Re: Submission to SSD-32766230 – Nos. 35-75 Harrington Street, The Rocks

We refer to State Significant Development Application No. SSD-32766230 which proposes the following works at Nos. 35-75 Harrington Street, The Rocks:

Submission to SSD-32766230

Sheet No.	Rev
DA-5011	01

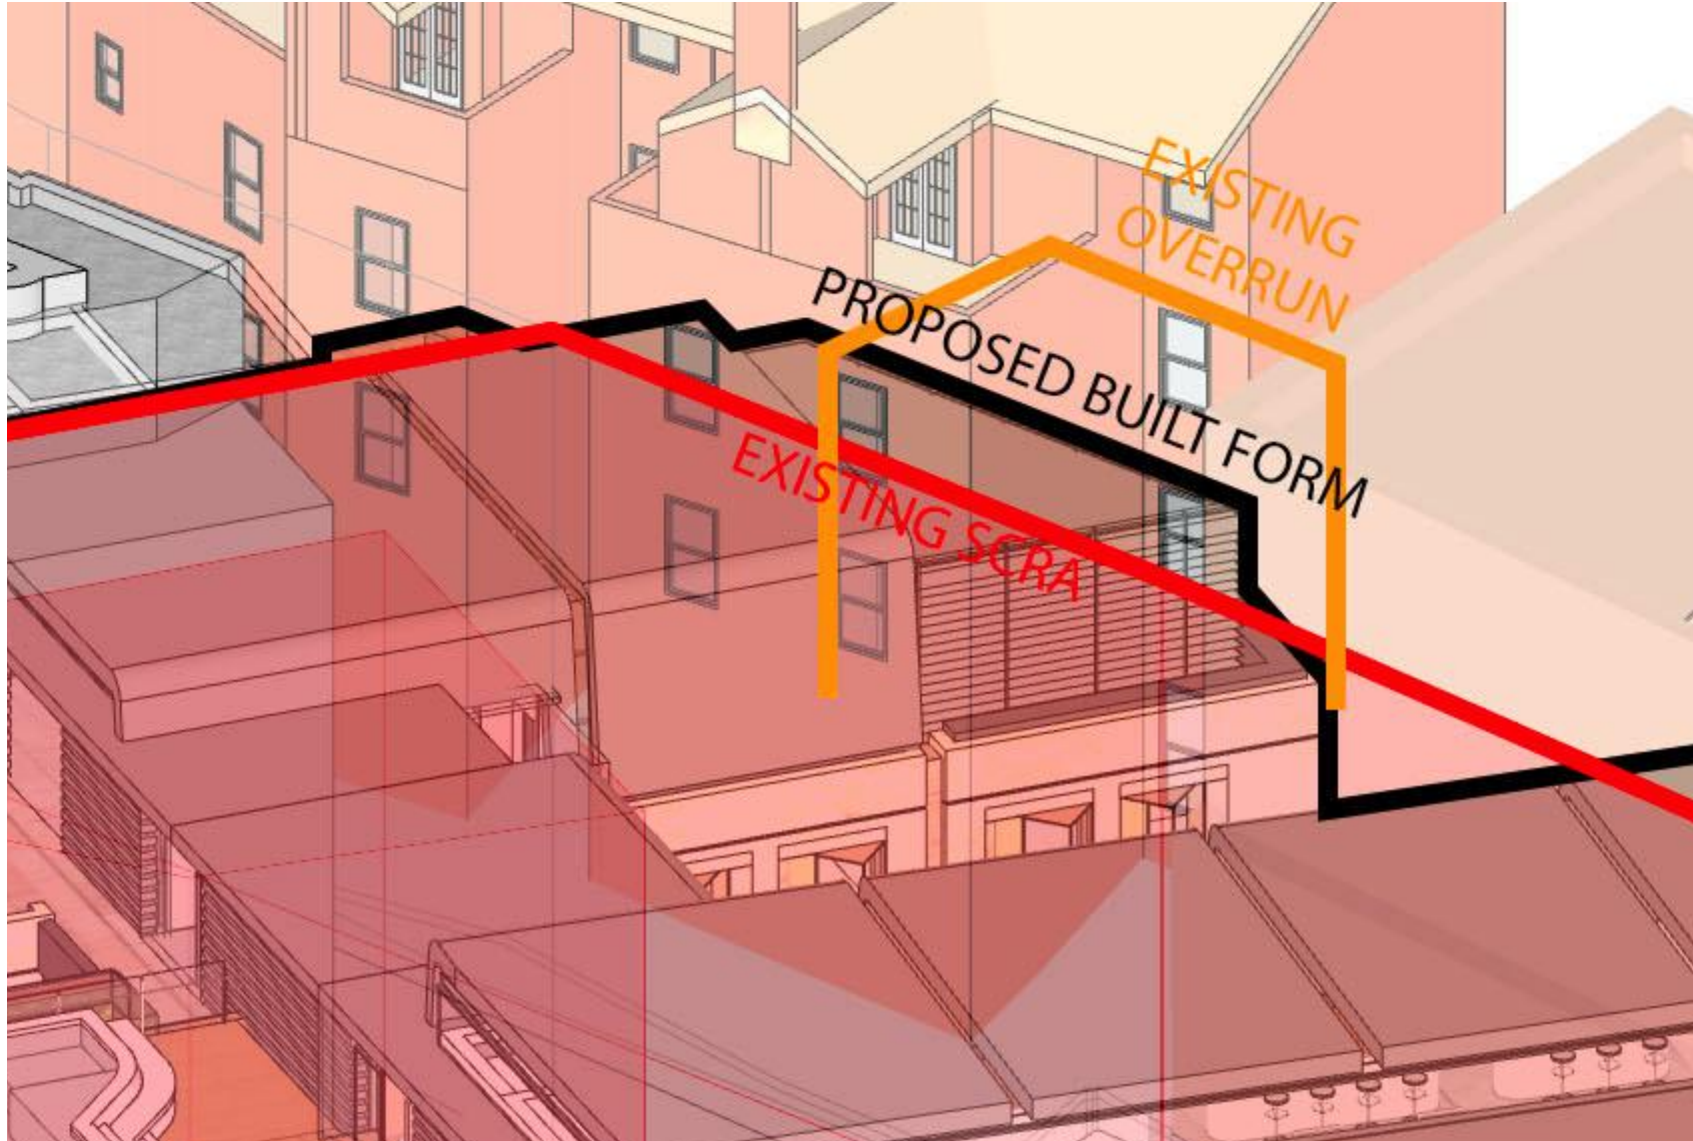
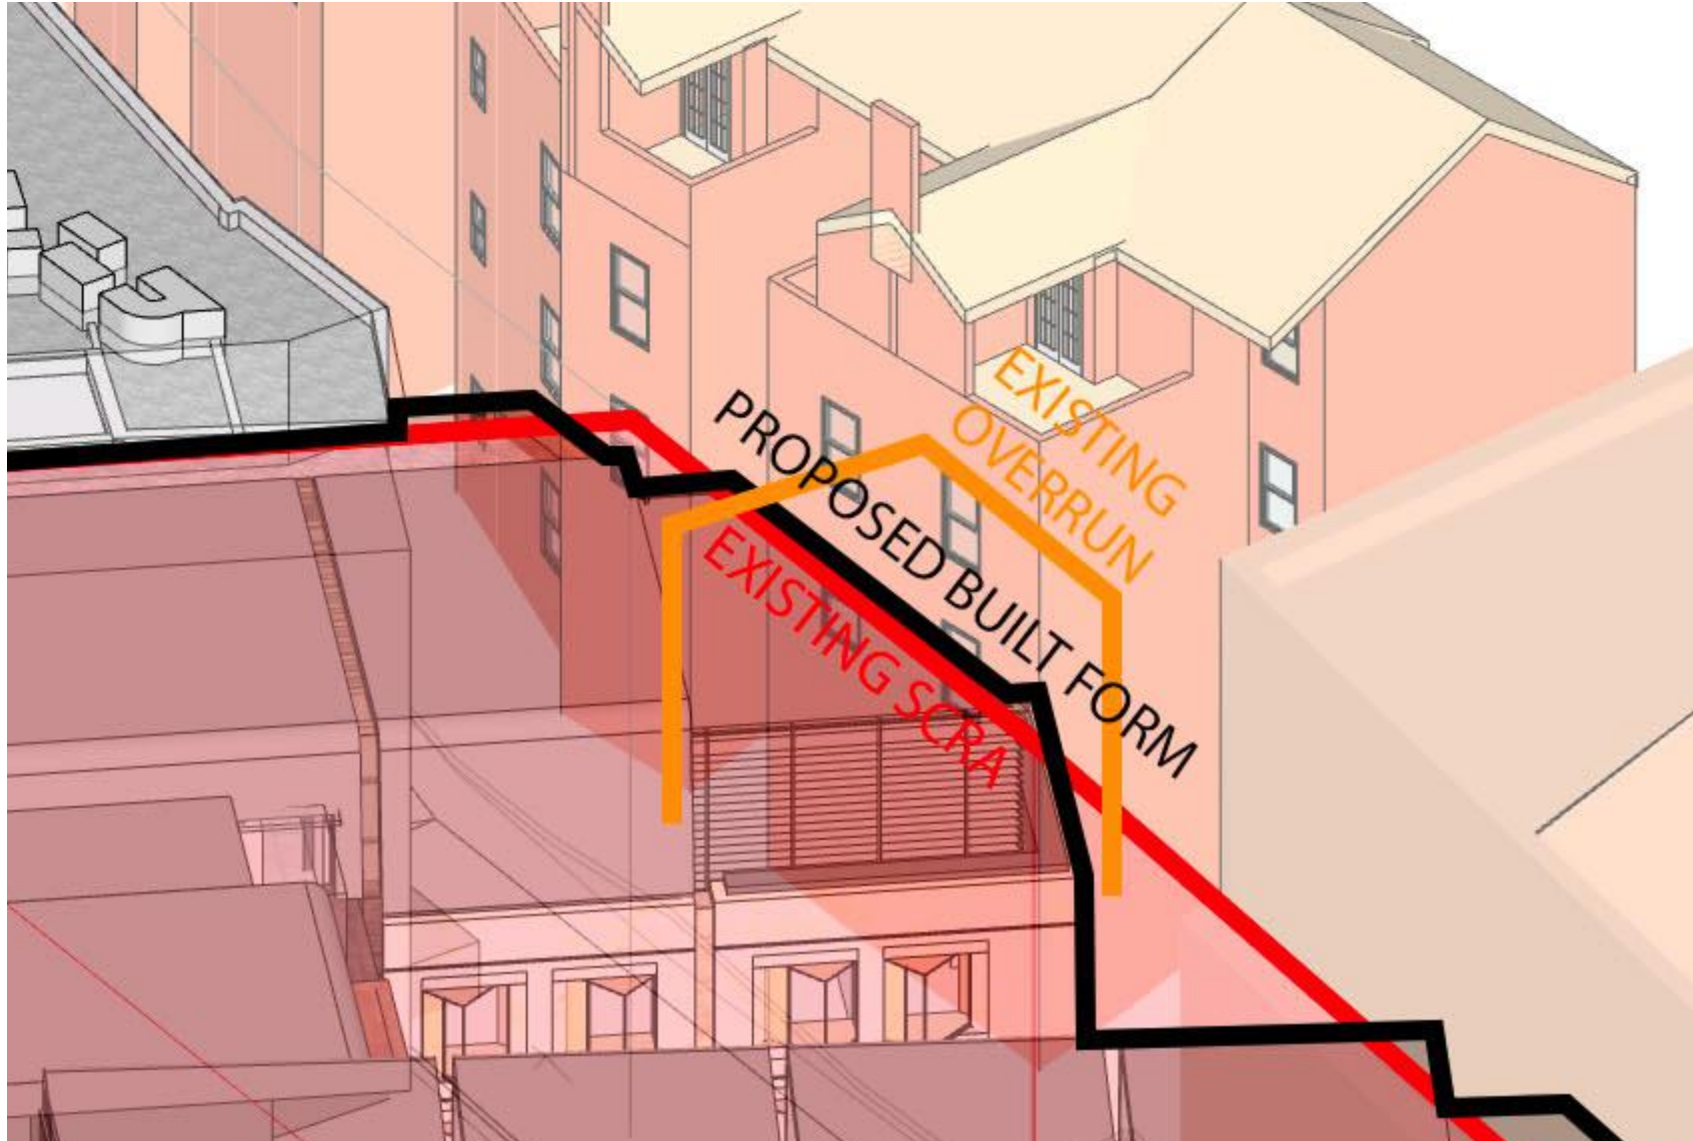
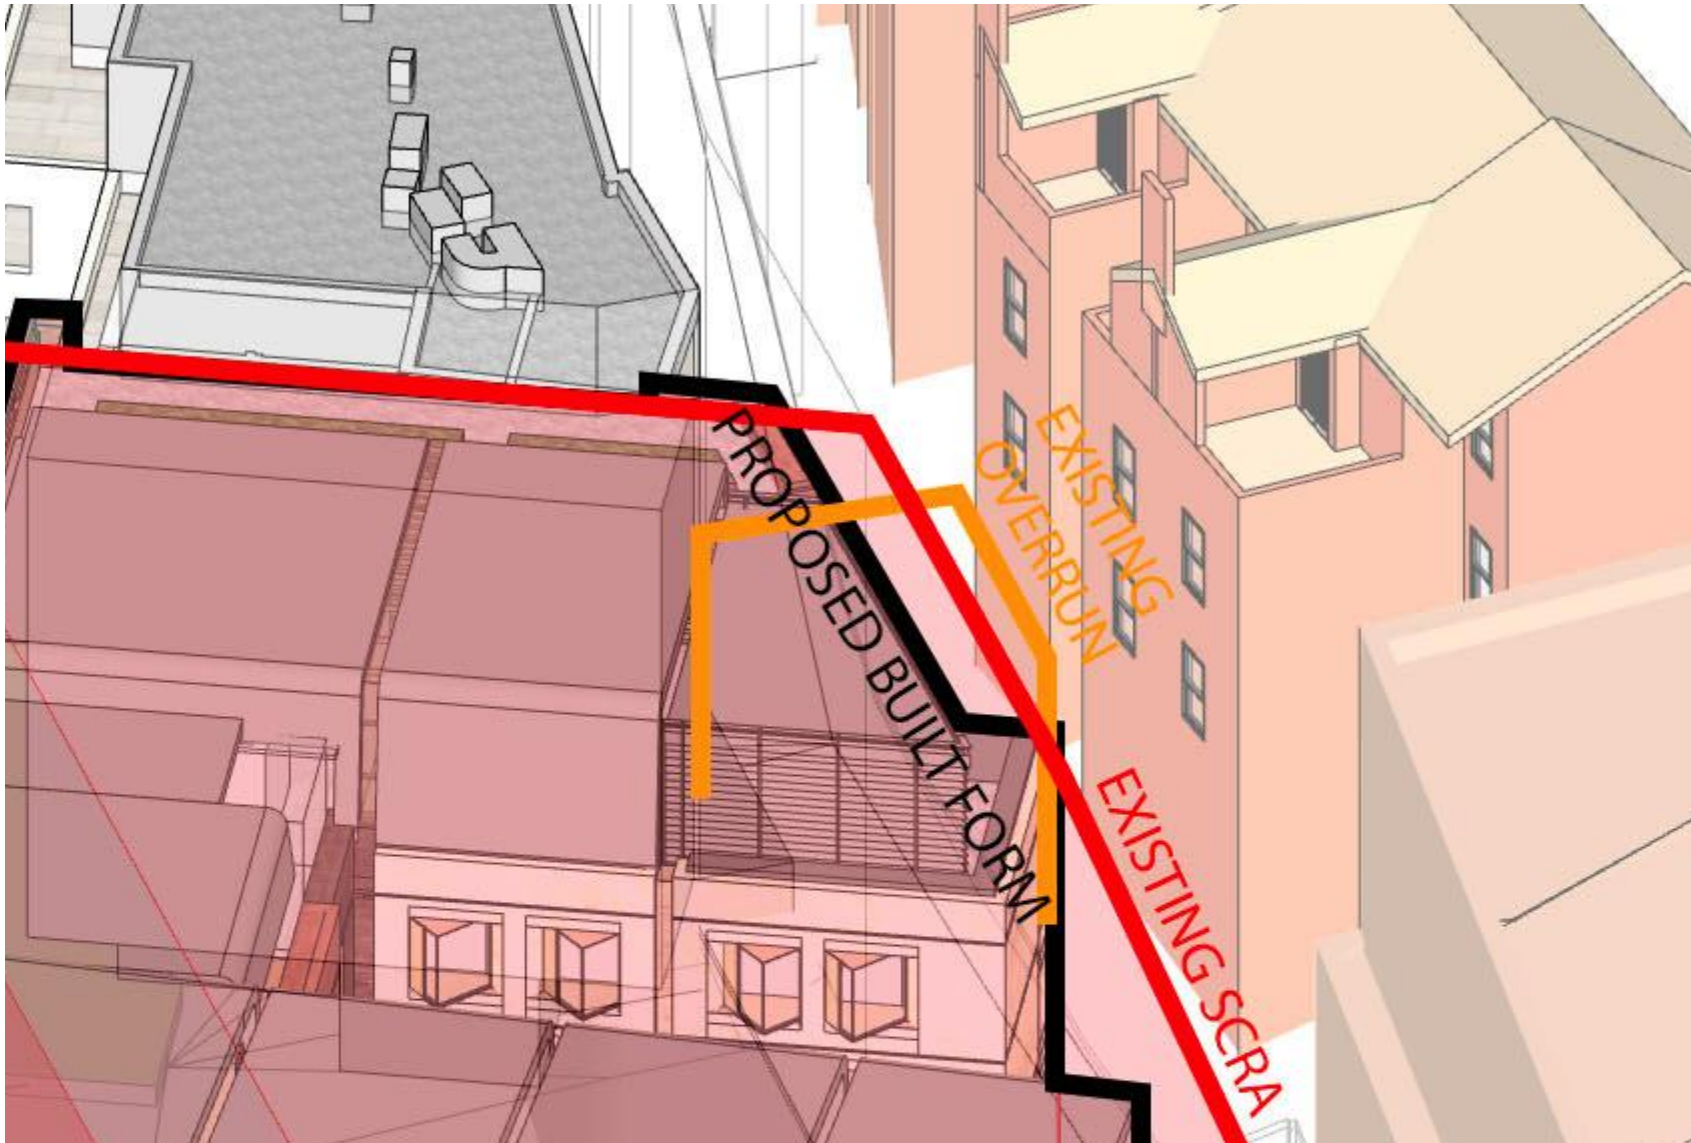
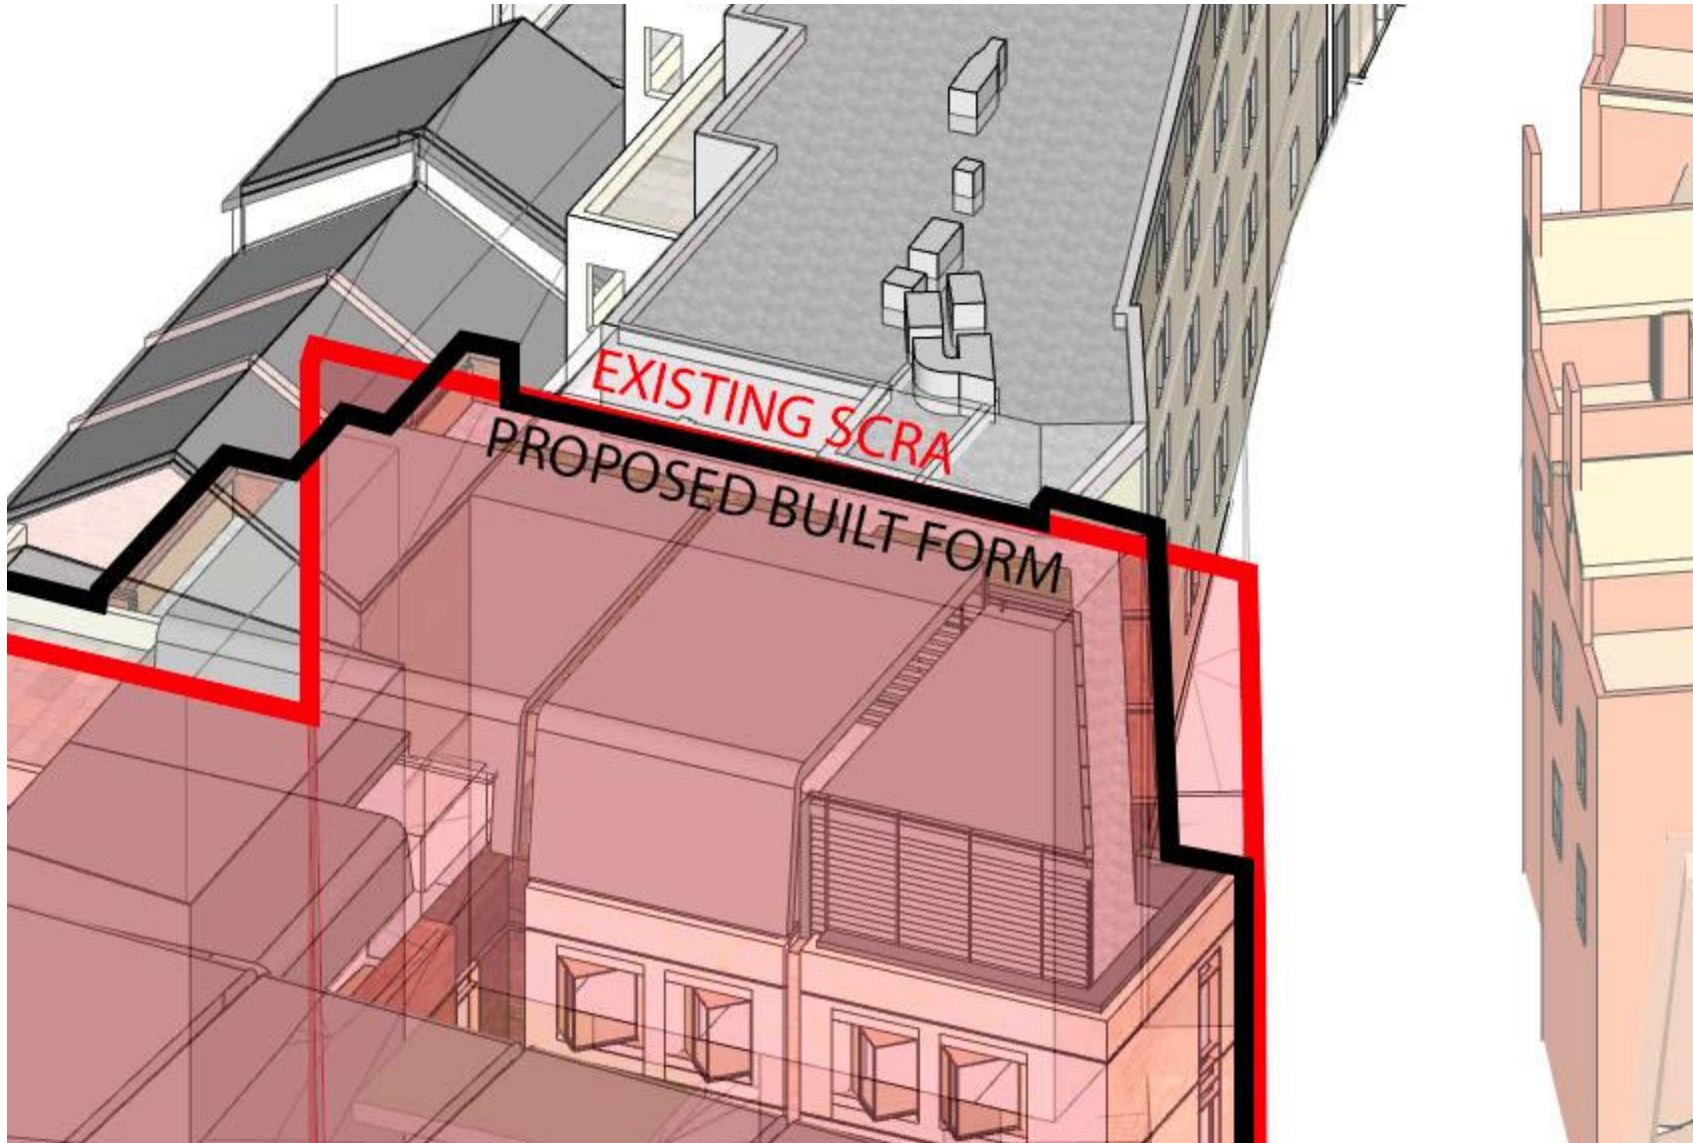
The increased in building height (i.e. +6.6m in the central and rear portions of the development site) will result in additional overshadowing impacts to the northern and western facades of No. 34-52 Harrington Street, between 2pm and 3pm (mid-winter and equinox) as noted in the applicants' shadow analysis documentation (see Figures 4 and 5 overleaf).

Whilst the proposed plans illustrate shadow impacts relative to the existing, approved SCRA scheme and proposed, the differential between such massing are ambiguous given the overlapping of colours.

It unclear if the existing and approved SCRA shadow diagrams denote the void below the existing clock tower (see Figure 6).

Further, the shadow diagram plans have not been drawn to scale nor include detailed analysis of impacts to fenestration.

As such, overshadowing impacts to the fenestration of the ‘Evans Stores, Harbour Rocks Hotel.’ have not been adequately addressed.

- Revised shadow diagrams are to be prepared to scale and clearly document shadow impacts to Nos. 34-52 Harrington Street (including existing fenestration).
- The shadow diagrams (in plan and elevation) are to be prepared at hourly intervals between 9am and 3pm (equinox and mid-winter) and clearly illustrate the following on separate sheets:
 1. Existing shadows.
 2. Shadows resulting from approved SCRA scheme.
 3. Proposed shadows.
 4. Cumulative impacts.
- Confirmation that the existing shadows impacts exclude the clock tower 'void'.
